# CITY OF ALBUQUERQUE

**Re: Weems Law Office**  
**106 Wellesely Dr. SE**  
**30-Day Temporary Certificate of Occupancy**  
**Transportation Development Final Inspection**  
Architect's Stamp dated 03-24-20 (K16-D090)  
Certification dated 10-05-22

SITE PLAN/ROOF PLAN 1" = 10'-0"

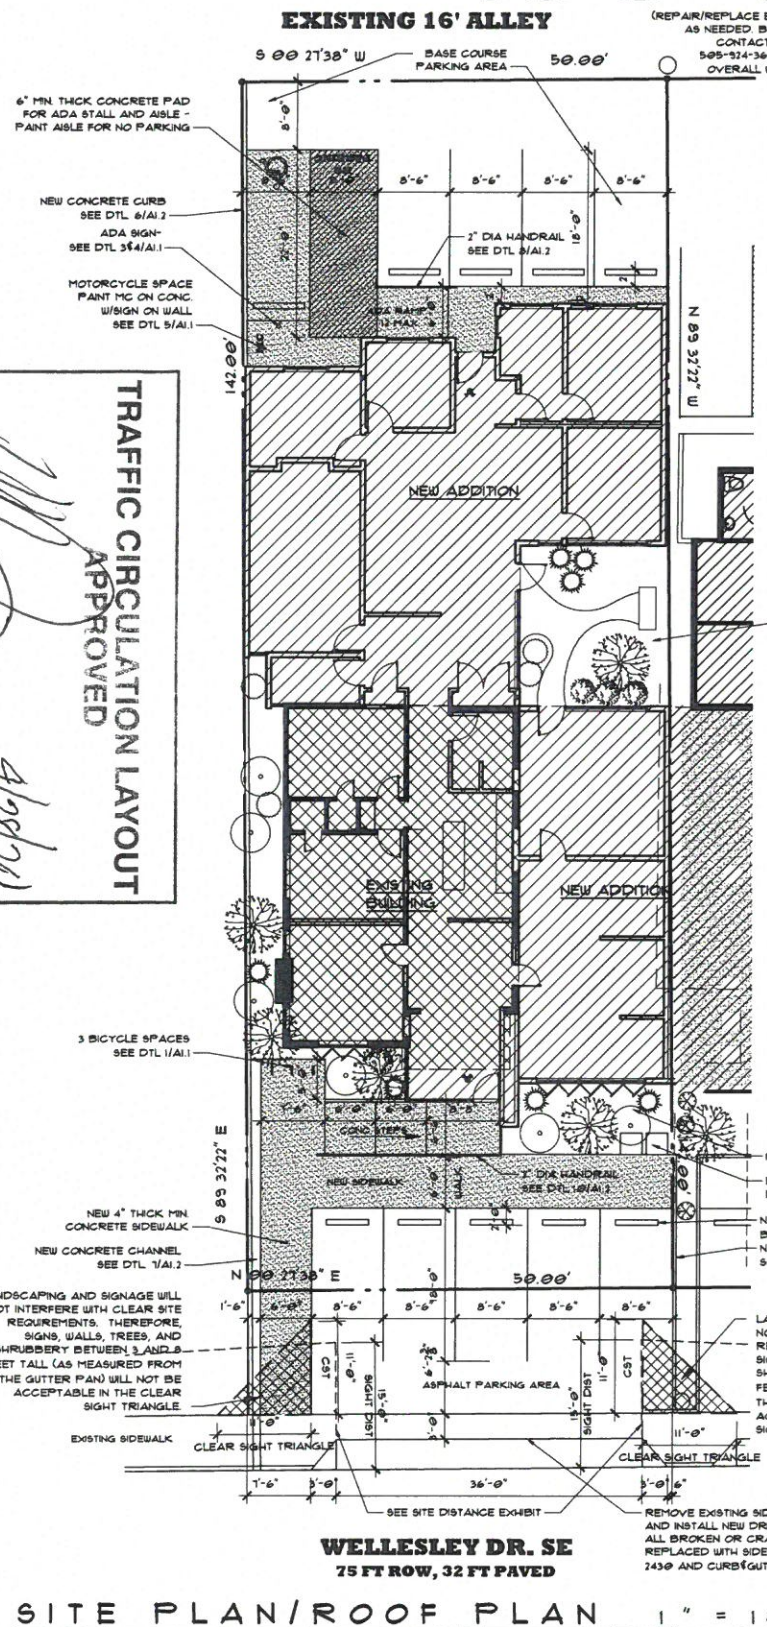
- Per the approved site plan, the ADA pathway from the public sidewalk to the building entrance is 6'. And the east parking area is base course. Per site visit, the pathway is 4' wide. And the east parking area is concrete pad. Please red mark the site plan to reflect changes to the site.
- The width for the ADA parking space should be minimum 8.5 ft. Per site visit, the width is 7.11 ft. please address this concern.
